Consultation Response from KC Conservation and Design
2019/92204 34, North Gate, Upper Hopton, Mirfield, WF14 8ET
Variation of condition 2 (plans and specifications) on previous permission 2018/92241 for Erection of single and two storey rear extension (Listed Building)
Date Responded: 27.8.19
Responding Officer: SO
Responding Ref:

ROOF PLAN

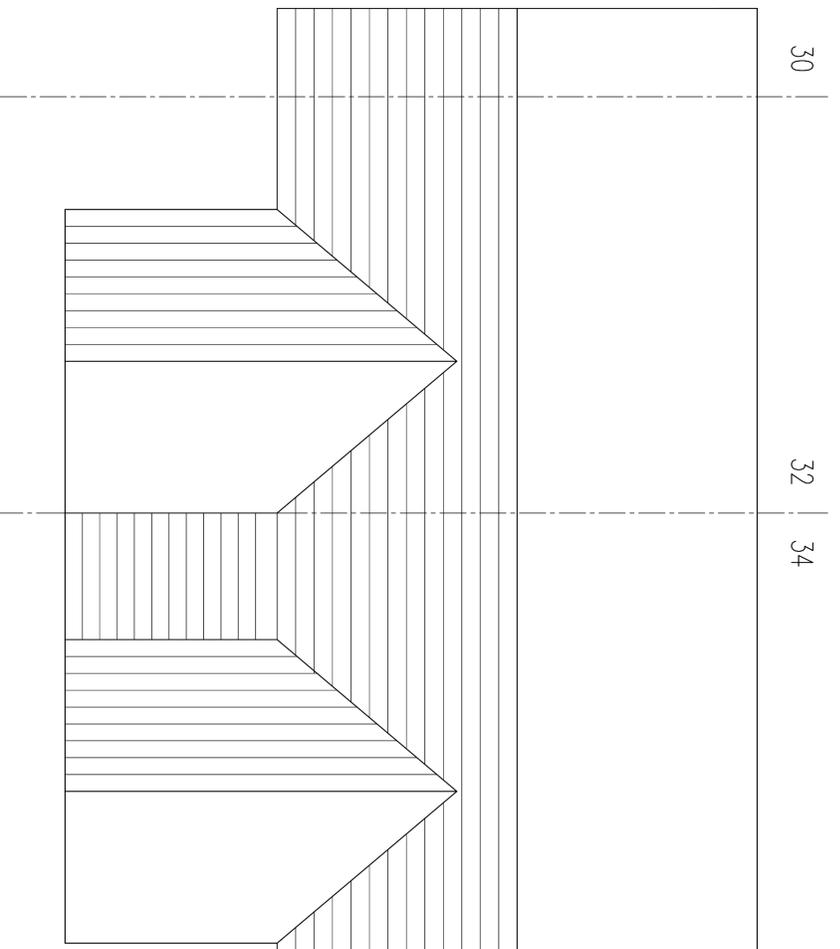
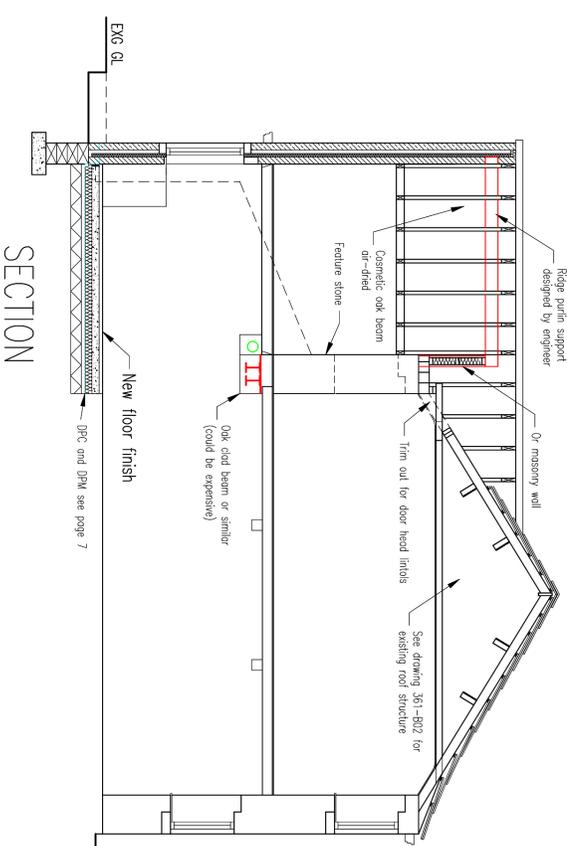
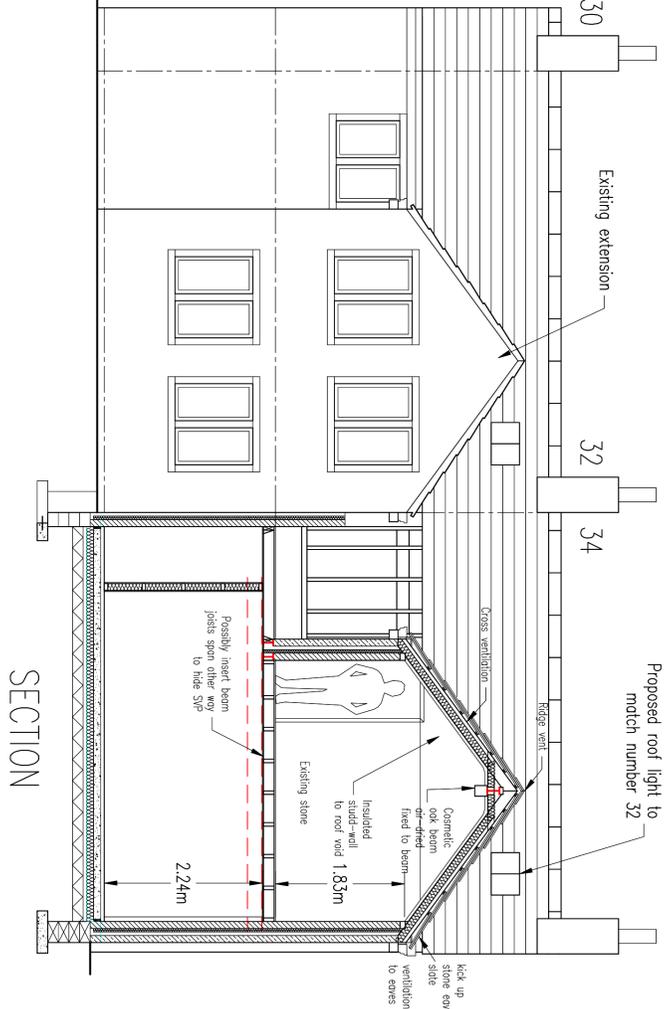
I would prefer the approved roof line to be retained above the proposed WC, with a first floor double window in a stone surround which reflects the style of the existing first floor windows and the retention of the eaves detail which show the historic roof line. This will also remove the need for three additional roof lights which I consider to be excessive.
